Appeal Decision

Appeal Ref: APP/R5510/D/14/2222267

42 Camden Avenue, Hayes, Middlesex UB4 0PW

- The appeal is made under section 78 of the Town and Country Planning Act 1990 against a refusal to grant planning permission.
 - The appeal is made by Mr Govind Parmar against the decision of the Council of the London Borough of Hillingdon.
 - The application Ref 16103/APP/2014/854, dated 14 February 2014, was refused by notice dated 2 May 2014.
 - The development proposed is single storey front/side extension.
-

PROPOSED SINGLE STOREY FRONT SIDE
EXTENSION (RETROSPECTIVE) AT
42 CAMDEN AVENUE - MAYBE MIDDX UB+OBW
SCALE: 1:100, 1:200
DATE: MARCH 2014
DRAWING NO: PARMAR-14-1

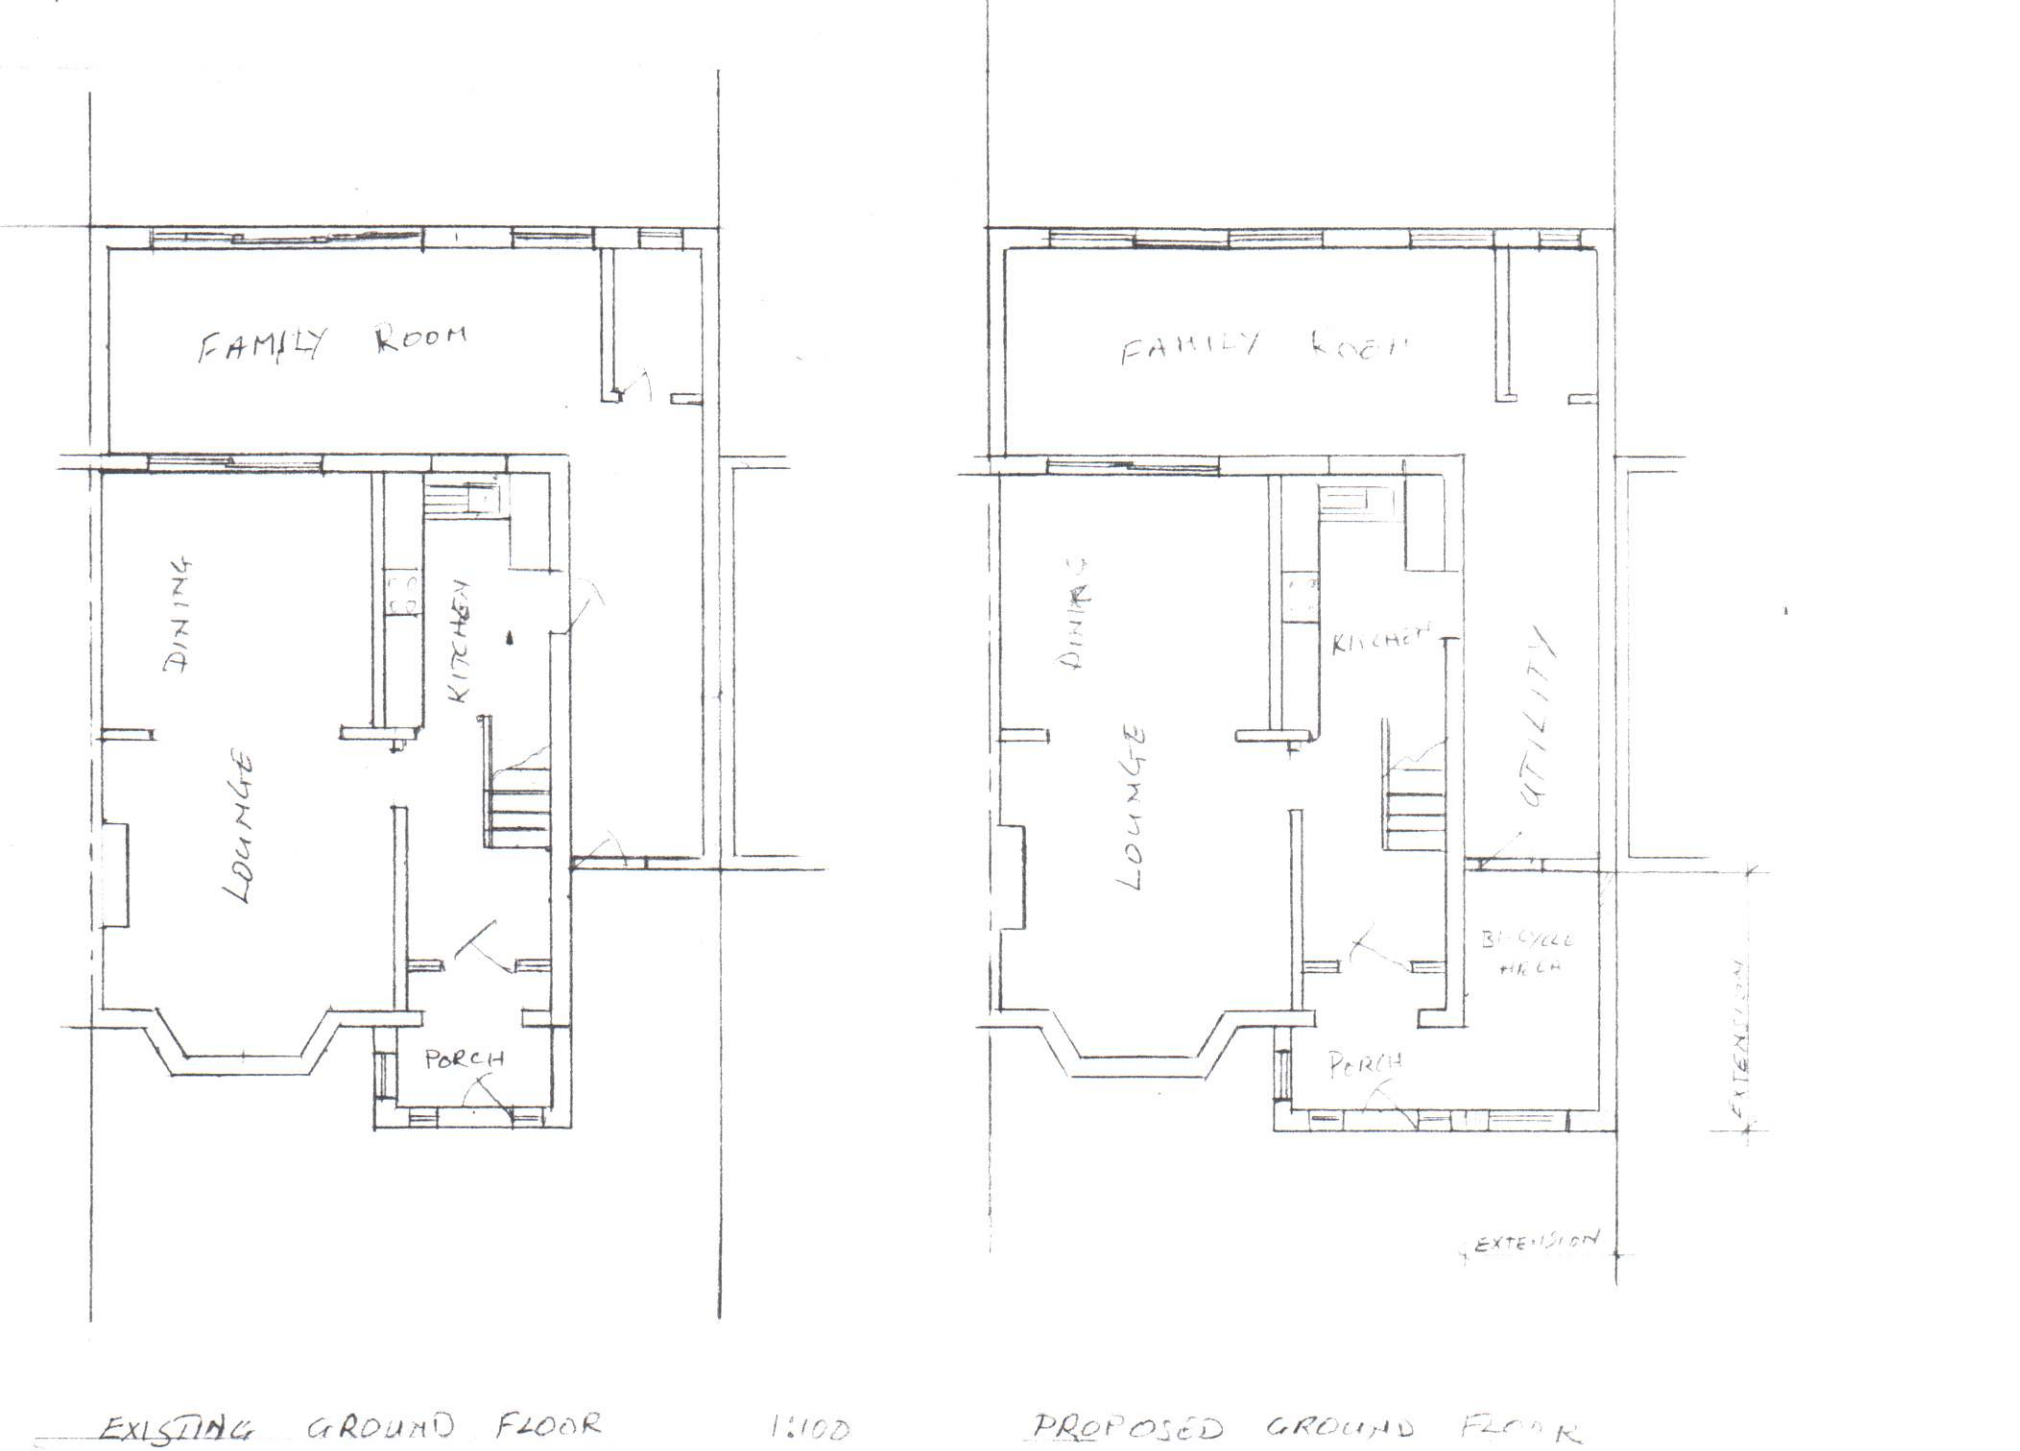
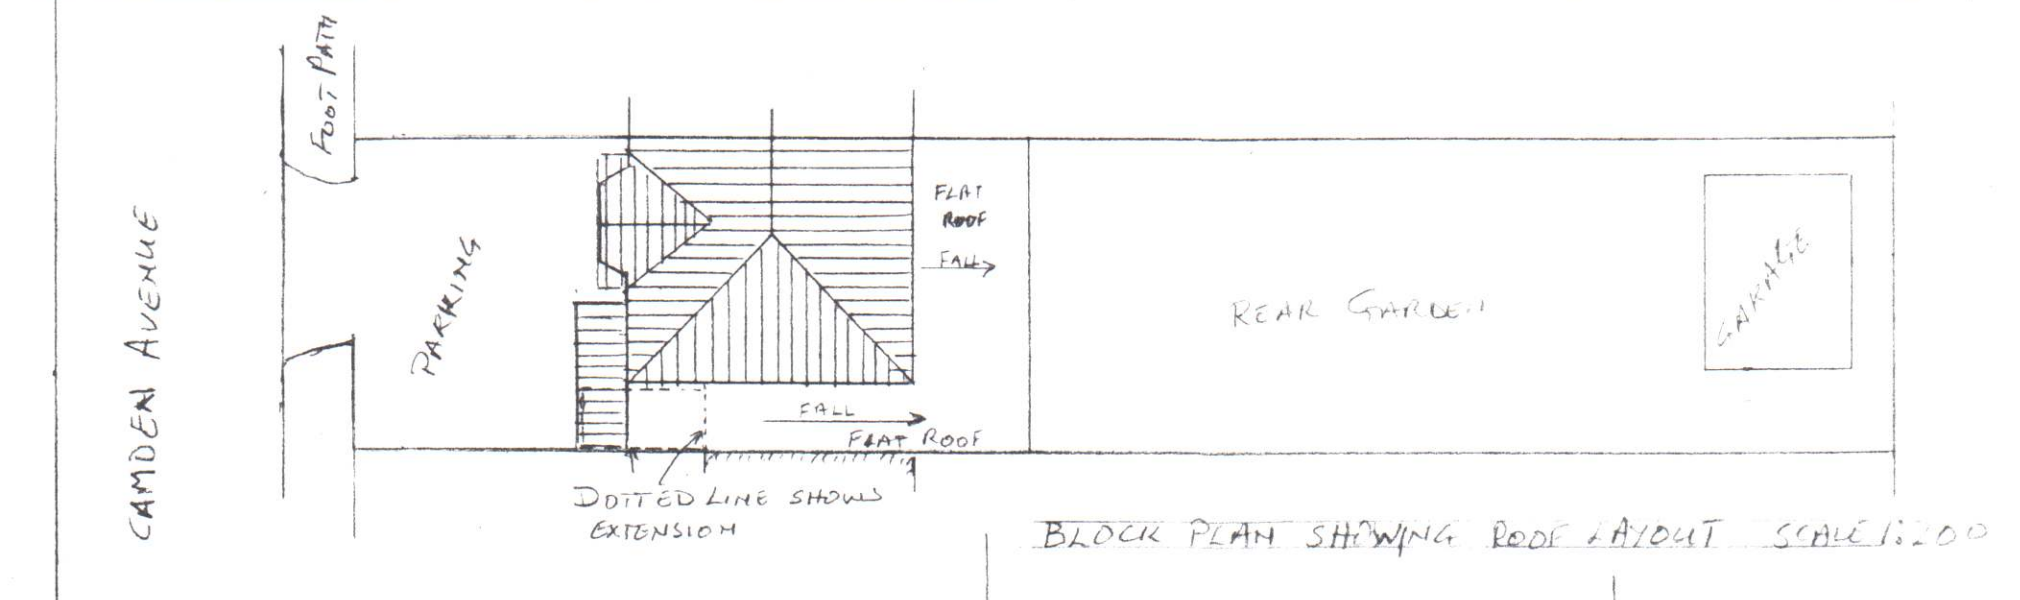
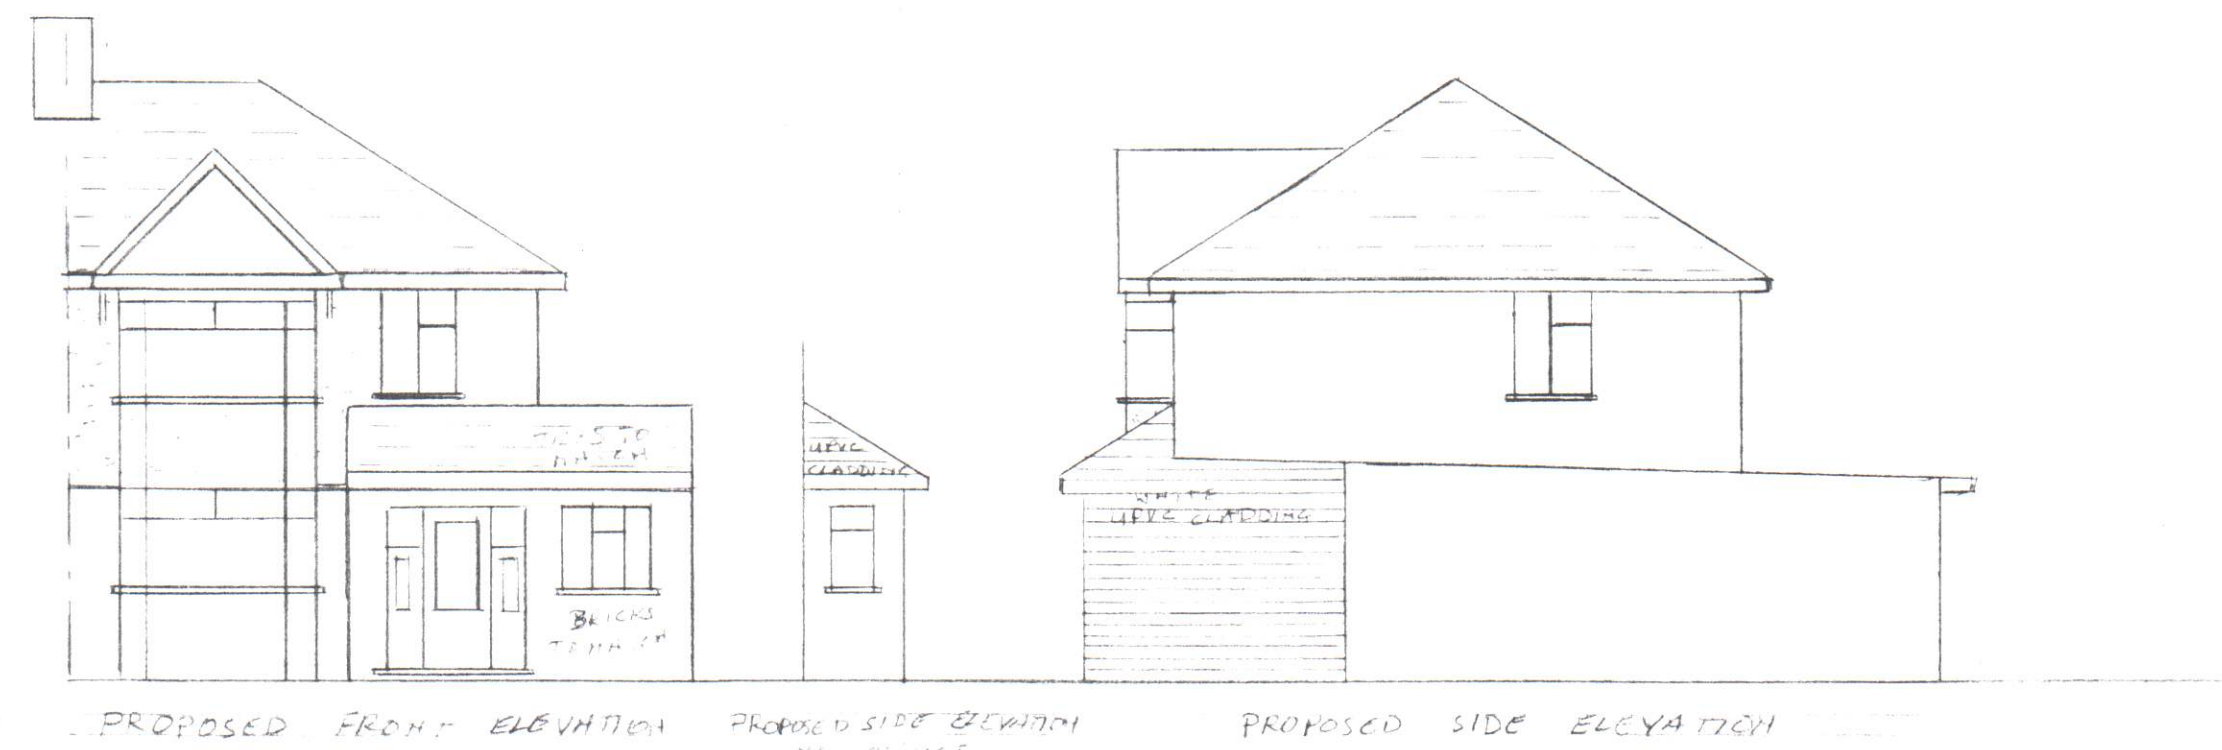
5. The development in this case consists of an extension to the front of the house which has a monopitched roof, and a side extension with a flat roof. There is a dummy pitched roof in front of the flat-roofed side extension.

street scene. The SPD requires that porches should not project past any bay, which this one does. Whilst the previous porch, which was damaged after being hit by a car, also projected forward, this is a larger extension and is therefore more dominant.

7. The SPD also says that porches should be subordinate in scale and form. It is certainly subordinate to the whole building, but it is nevertheless a bulky and discordant addition to the dwelling, with an awkward junction between the dummy pitched roof of the front extension and the flat roof of the side extension, which accentuates its incongruity. This conflicts with the SPD advice that changes and extensions to the front of the house must be minor and not alter the overall appearance of the house or dominate the character of the street.

8. Whilst I accept that there is some variation in the appearance of the fronts of houses in the street, I consider that the appeal example is unduly dominant and of poor design which is harmful both to the host building and to the street scene in general.
